Martin Nugent
01254 828060
D3/12/0770

Drafted 25 September 2012

**Planning Application, Ribble Valley District
3/12/0770 land off Fairfield Avenue, next to the gable of 1 Lilac Grove, Clitheroe**

Project New Car Parking Bays Faifield Drive/Lilac Grove, CLITHEROE			
Title Proposed Layout			
Scale 1/100	Drawn Date Sept 2012	Checked Date	Approved Date
CAD Ref

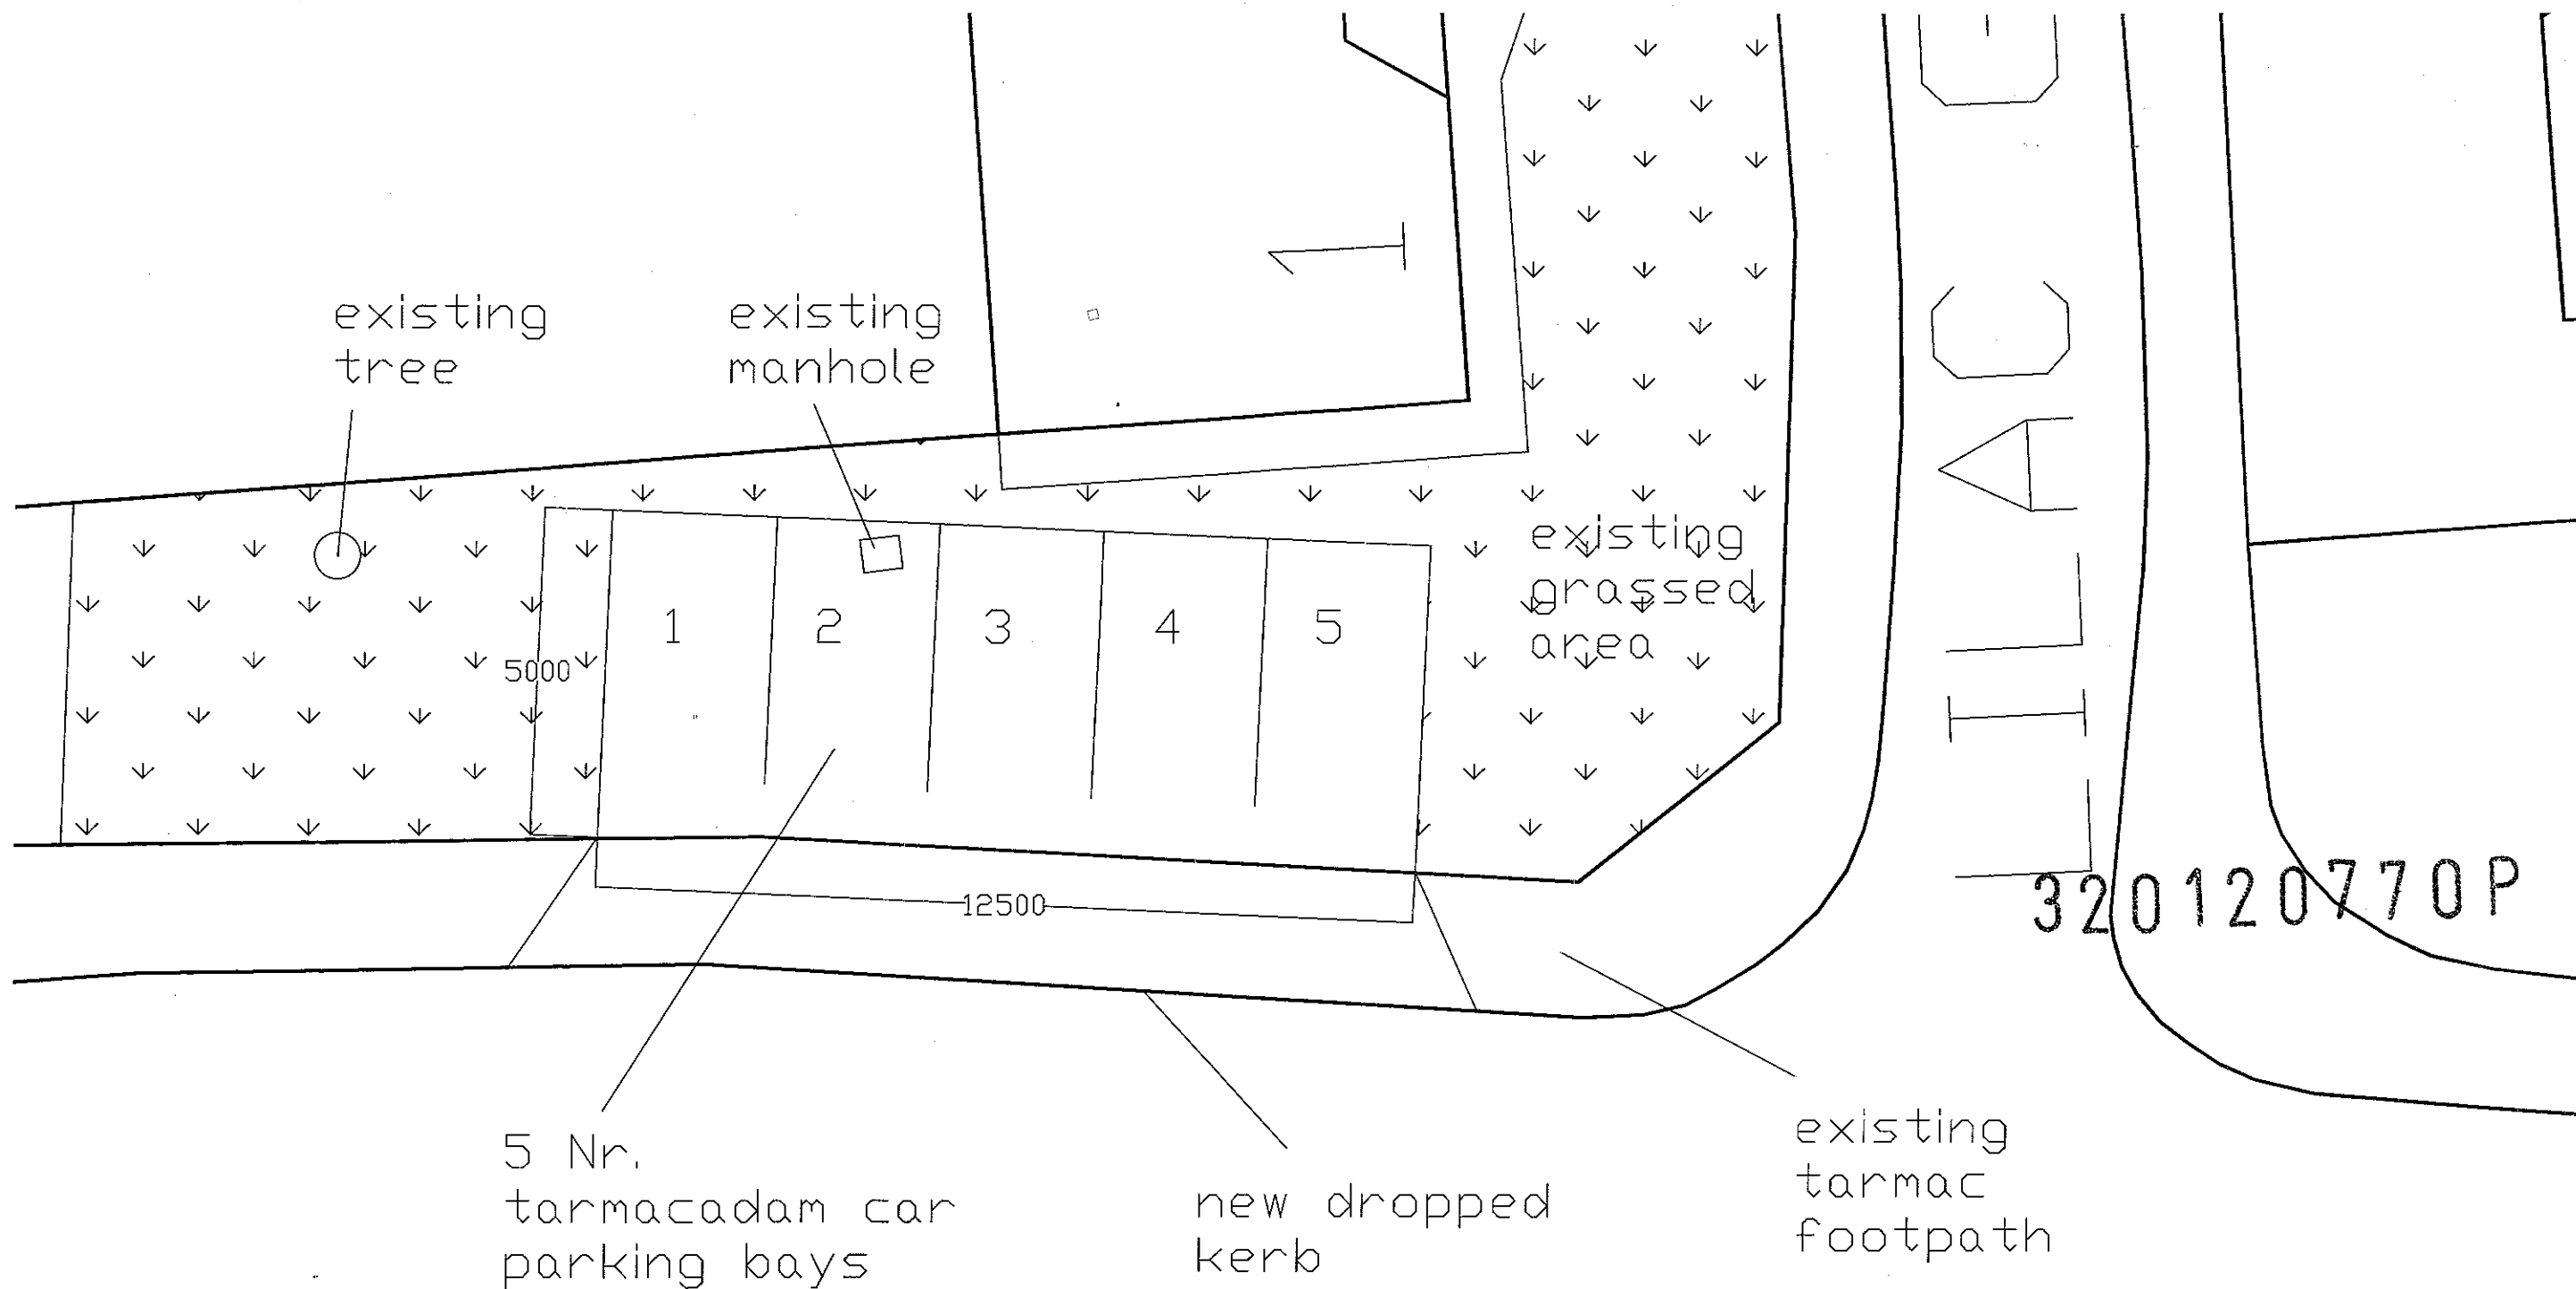
However, the layout for the combined driveway access must be designed to comply with LCC recommendations, as detailed below.

The creation of the new access will require the provision of an additional drop kerb and associated alterations to the existing footway. Accordingly, the following Conditions should be included in any consent:-

A. The kerbing at the vehicular crossing shall be reinstated in accordance with the Lancashire County Council Specification for Construction of Estate Roads, concurrent with the formation of the improved access. This is to provide the necessary access and to maintain the proper construction of the highway.
